JUDGE ORR RANCHETTES

PRELIMINARY PLAN

EL PASO COUNTY, COLORADO

JUDGE ORR
RANCHETTES
PRELIMINARY PLAN

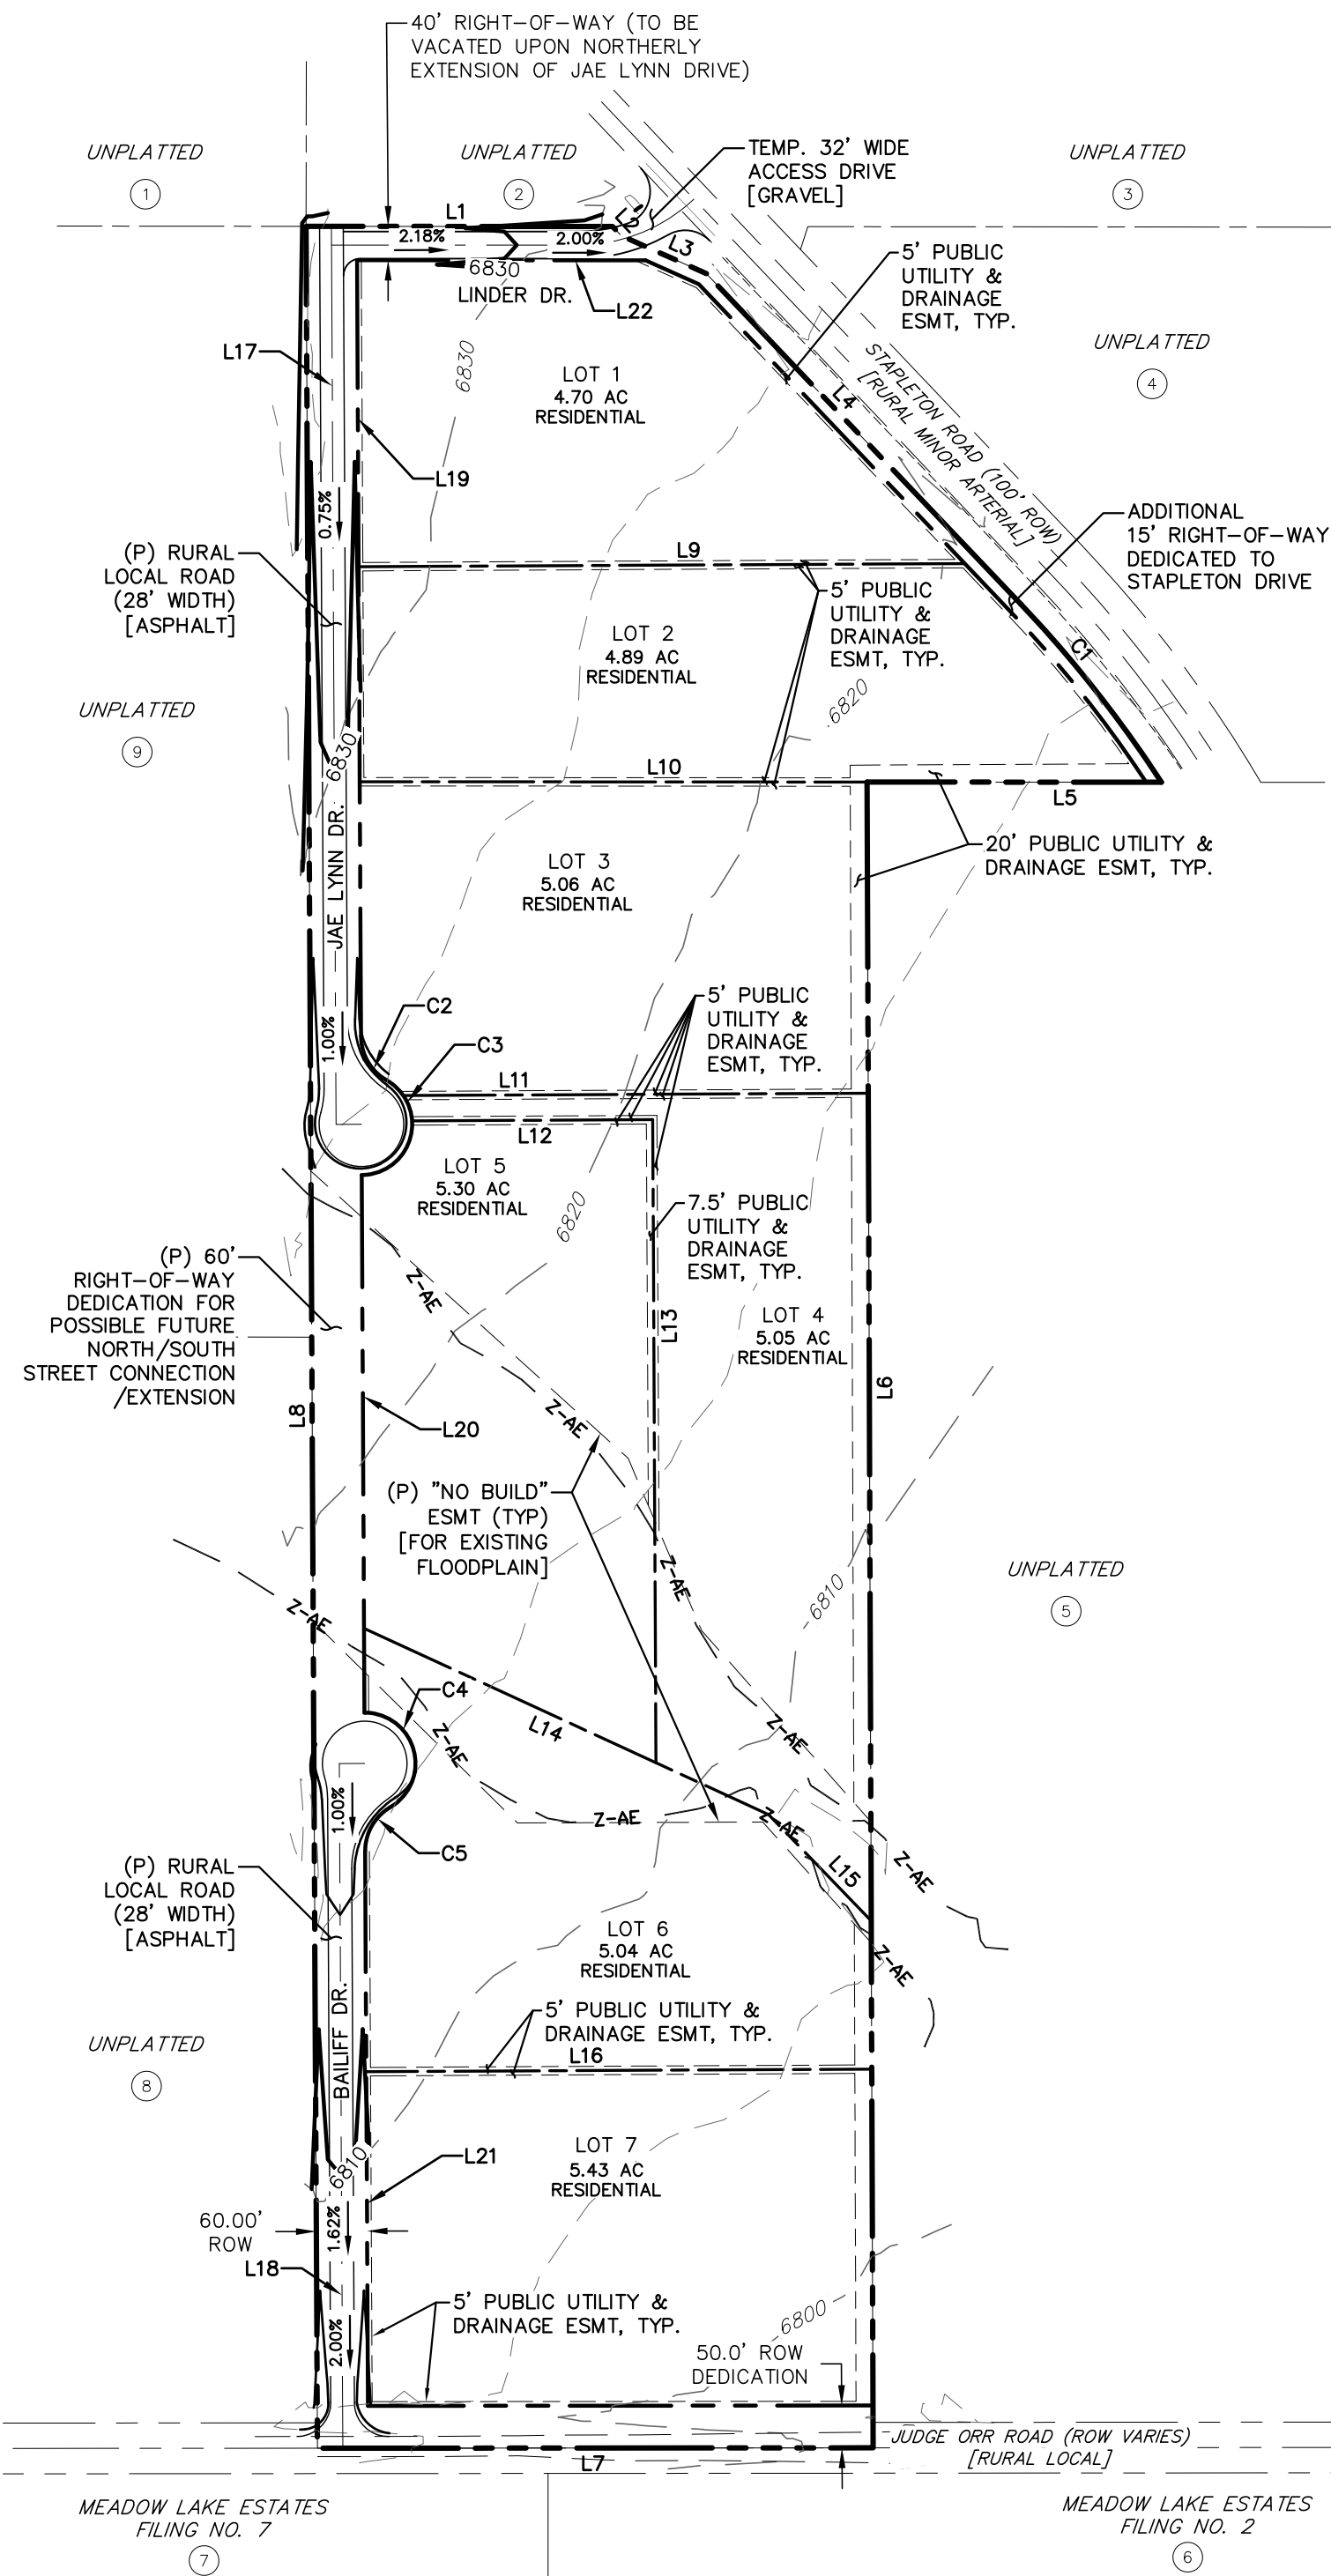
Add notes for services, fees to be paid (park, school, drainage, traffic). If building sites have been determined, please add.

please relocate indicator so it cannot be confused with the floodplain

Add net acreage calculations for lots impacted by no build.

indicate ROW dedication width

Add SP-17-011

there are two property lines here

Add section, township, range
